82 Church St
Camperdown 2050

20 Sep 2012

Response to RPAH North West Precinct Development (MP 10_0166)

DEPARTMENT OF PLANNING SUBMISSION
PHOTOMONTAGE PERSPECTIVE - SHEET 1
ROYAL PRINCE ALFRED HOSPITAL
North West Precinct Project, Camperdown

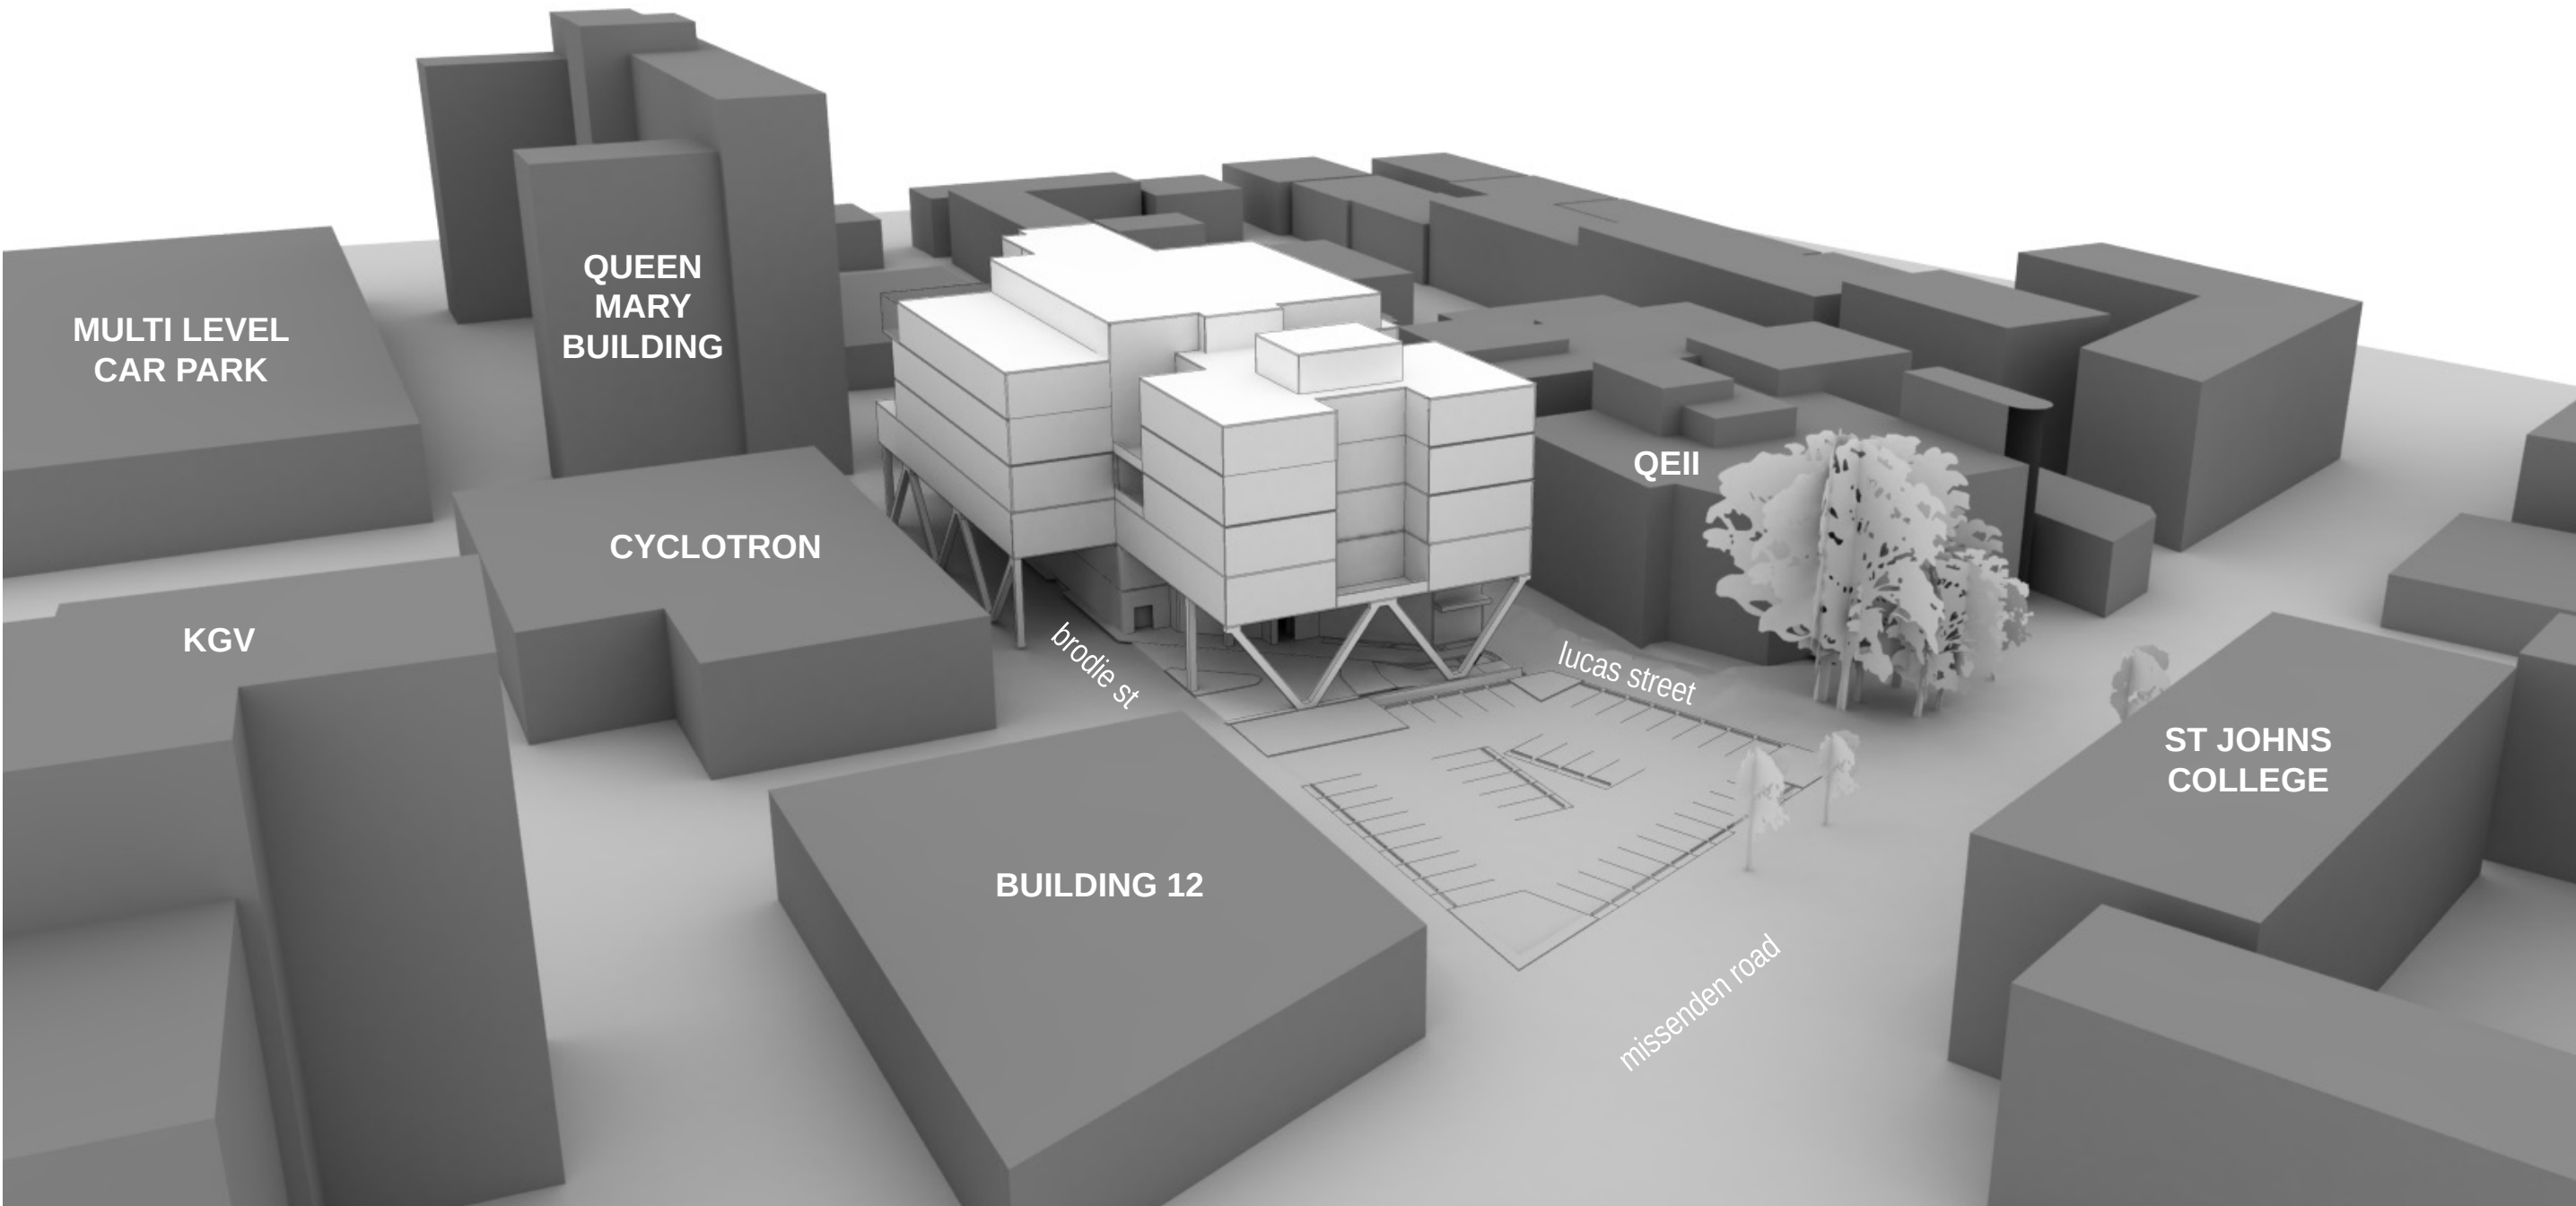
1. Prominent white angled supporting concrete pillars

The pillars appear to have been designed as a deliberately prominent part of the building, whose prominence is enhanced by:

- Obliqueness - the angles are in sharp contrast to the horizontal-vertical planes of the rest of this building and most other surrounding built structures
- Brightness - the bright white colour is another sharp contrast to the muted tones of brick, concrete and other usual building materials
- Connectedness - the pillars form a strong zigzag at the base of the building which wraps around its sides and connects to the other white horizontal-vertical elements.

2. Facade

Like the pillars, the patterned precast concrete of the facade facing Missenden Rd appears to have been designed as a deliberately prominent part of the building, whose prominence is enhanced by the number of same-width lines at different angles and rectangular cutouts revealing the glass.

3. Triangular side features

The Lucas St base of the building appears to be faced with large grey and white triangles.

I submit that the building's diversity of prominent oblique angles presents a strong and visually discordant impact on the streetscape which may have an effect other than "ensur[ing] the patient experience is welcoming and nonthreatening" [1]. While nobody wants a hospital to be a tedious uniformity of drab rectangular concrete boxes, thoughtful design should provide a happy marriage of utility, visual interest, and soothing the anxieties often associated with hospital visits.

- Pillars - a more neutral or "invisible" colour instead of white, to increase the impression that the building "floats"; wrapping the pillars in a vine to give the impression of an organic support; or increasing the extent of the existing trellis to fill but not occlude the inter-pillar spaces.
- Facade - use of a different textured or patterned material with curved lines or sections.
- Side - use of a non-adherent vine on a close mesh trellis.
